**ADC Planning Consultation
Conservation/Design Officer Response**

Application Number	AW/155/17/PL
Address	28A Kingsway Aldwick
Description	Construction of a new dwelling within a designated area
Case Officer	Simon Davis
Date	5 July 2017

Existing + Proposed Street Elevation

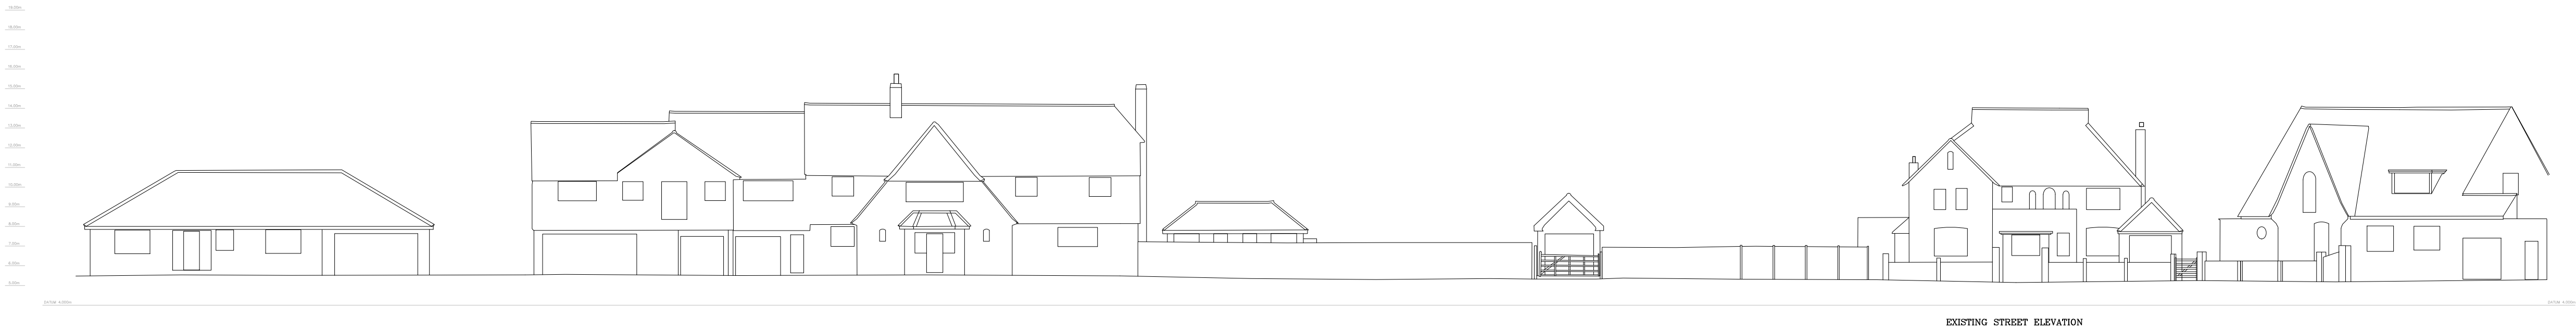
While it is noted that attention has been given to locally appropriate detailing, bulky first floor dormers and front rooflights are not typical elements in the streetscene, where roofscapes are generally uncluttered. The dormer should therefore be reduced to three lights in width to reduce its overbearing appearance and the front rooflights should be entirely omitted.

1. Omission of the front rooflights
2. Reduction in width (to three lights) of the dormer above the garages
3. Approval of materials samples
4. Approval of details of the front boundary treatment
